21 June 2021

**Loreto Normanhurst School Redevelopment (Concept Proposal and Stage 1) (SSD-8996)  
Request for additional information**

Aditi Coomar  
Team Leader  
Social & Infrastructure Assessments

S1-003

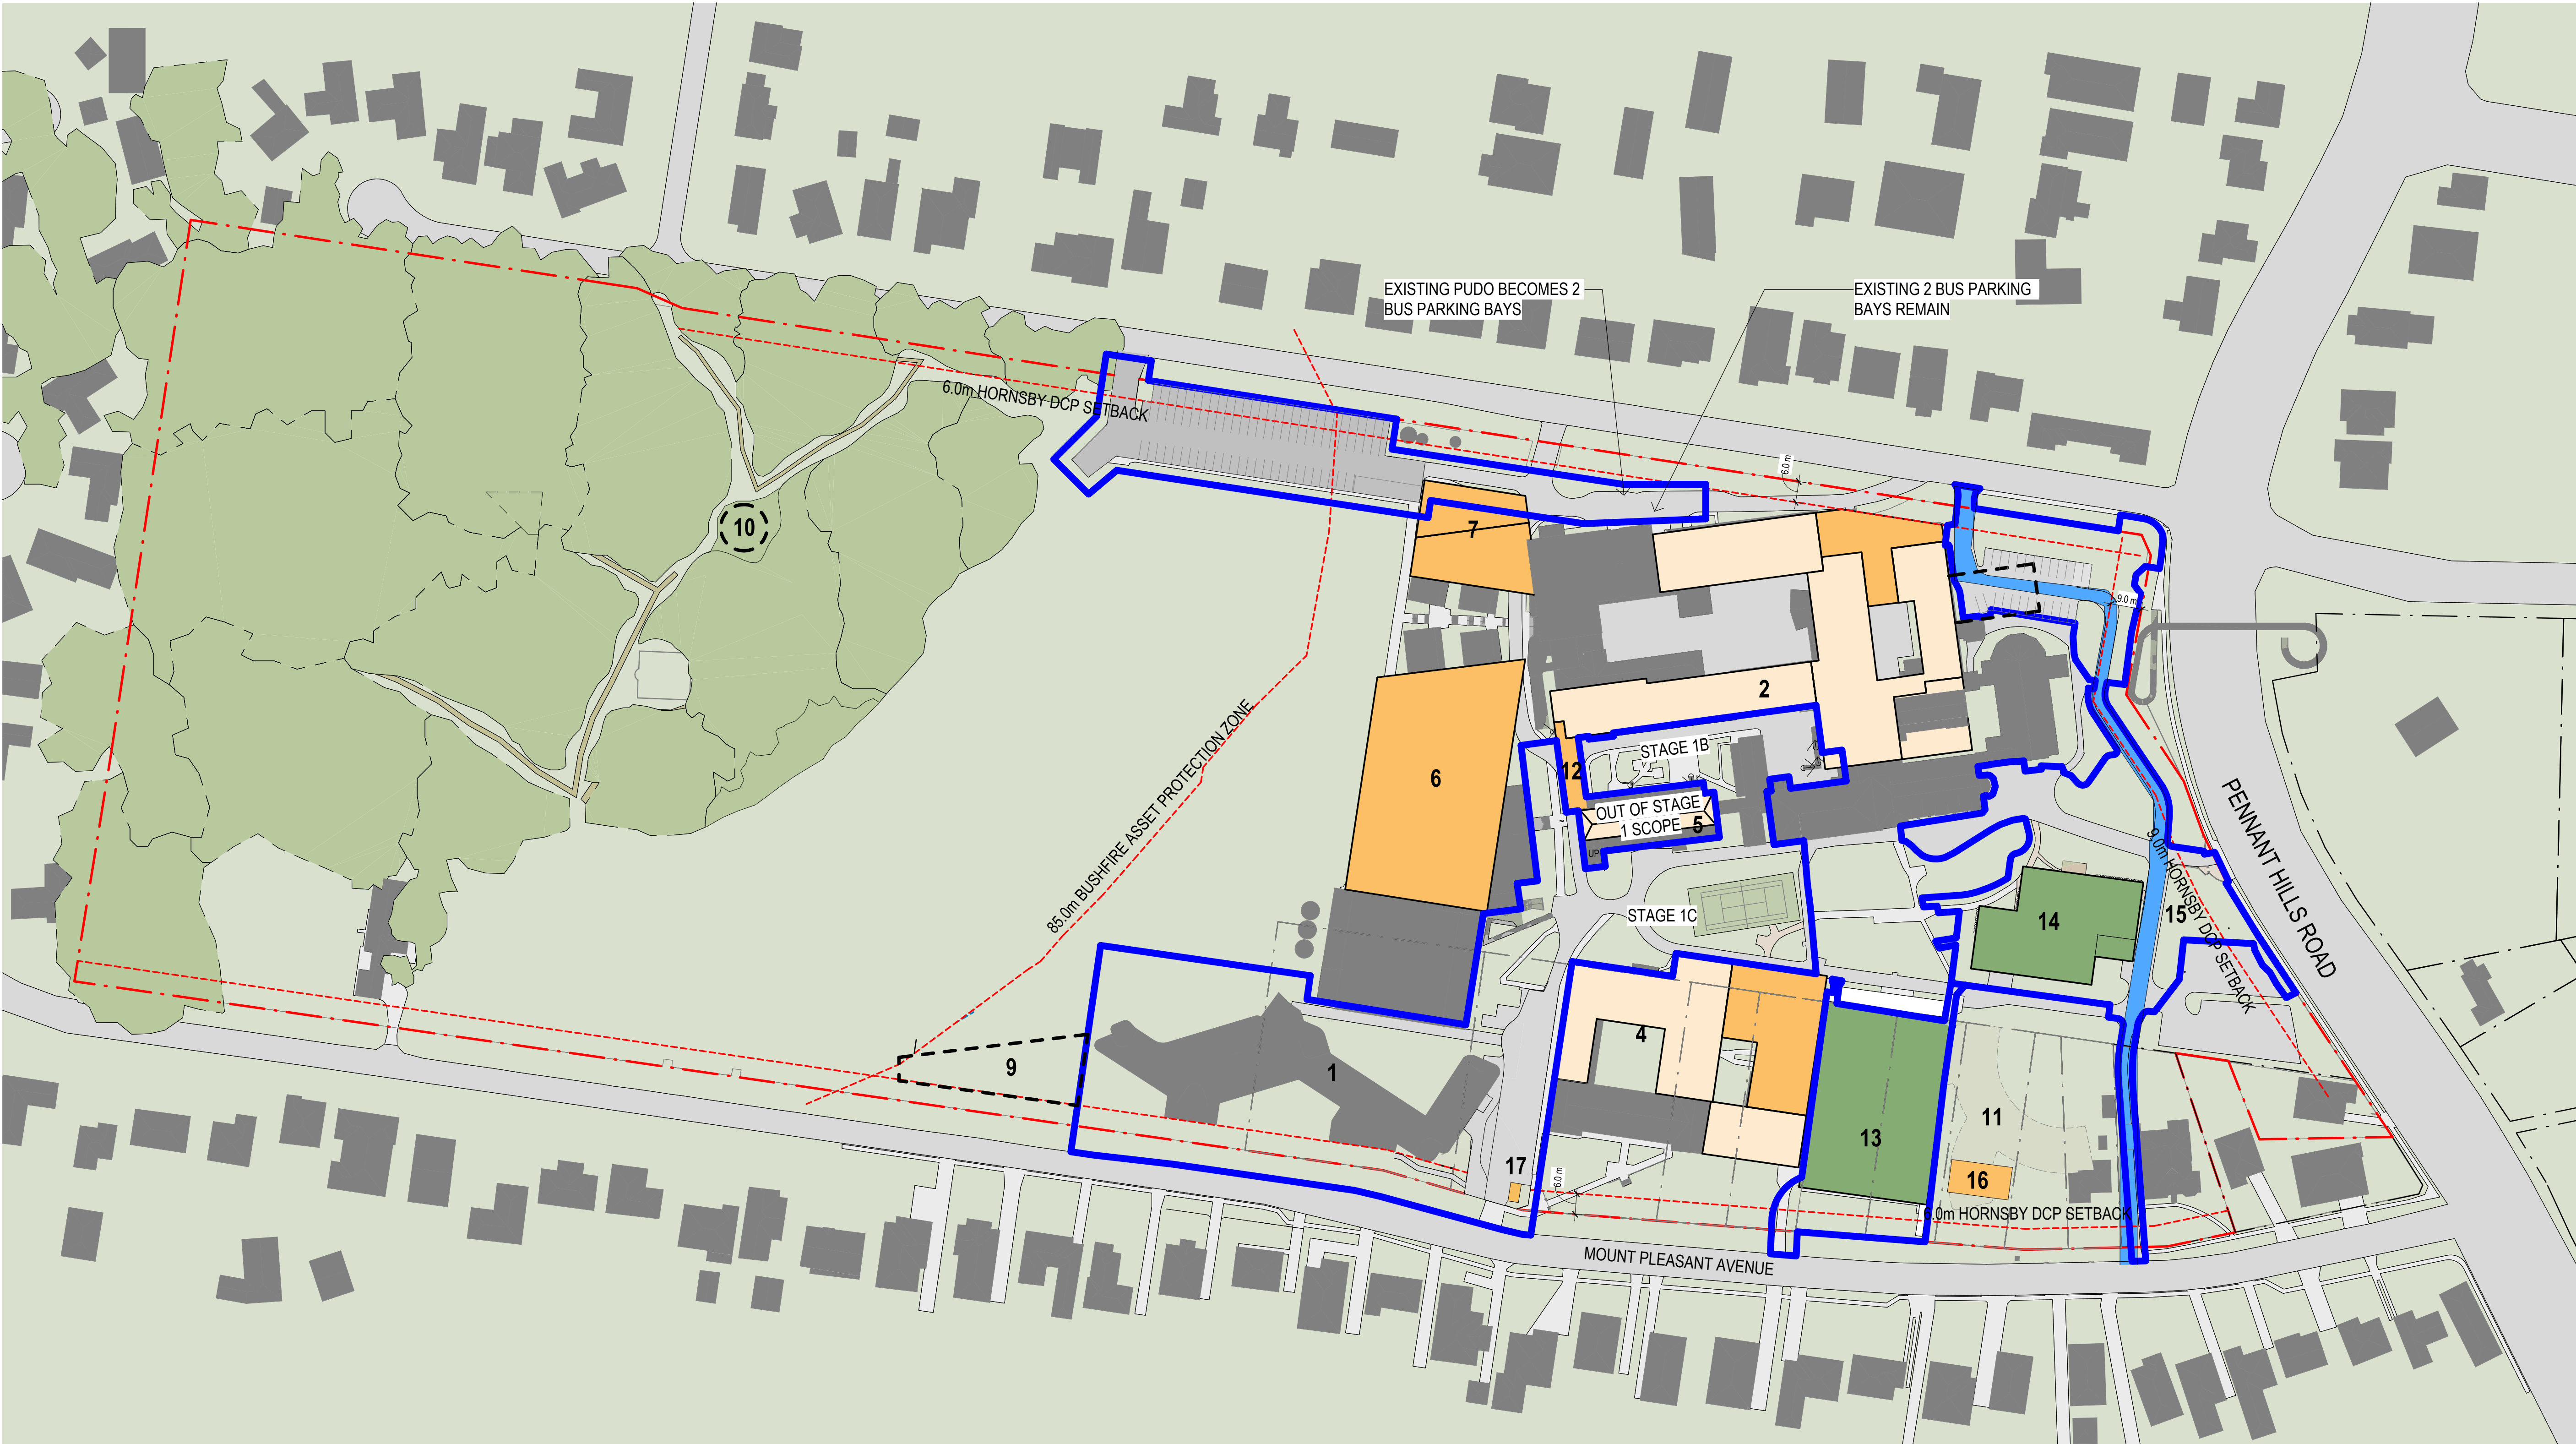
Additionally, it is noted that the proposed substation and switchboard are located outside the Stage 1 scope of works boundary shown on the architectural drawings (Nos. A0003, S1-003 and S1-004). If consent is sought for these structures as part of the Stage 1 works, they need to be clearly shown on the architectural and landscape drawings as being within the scope of the Stage 1 works.
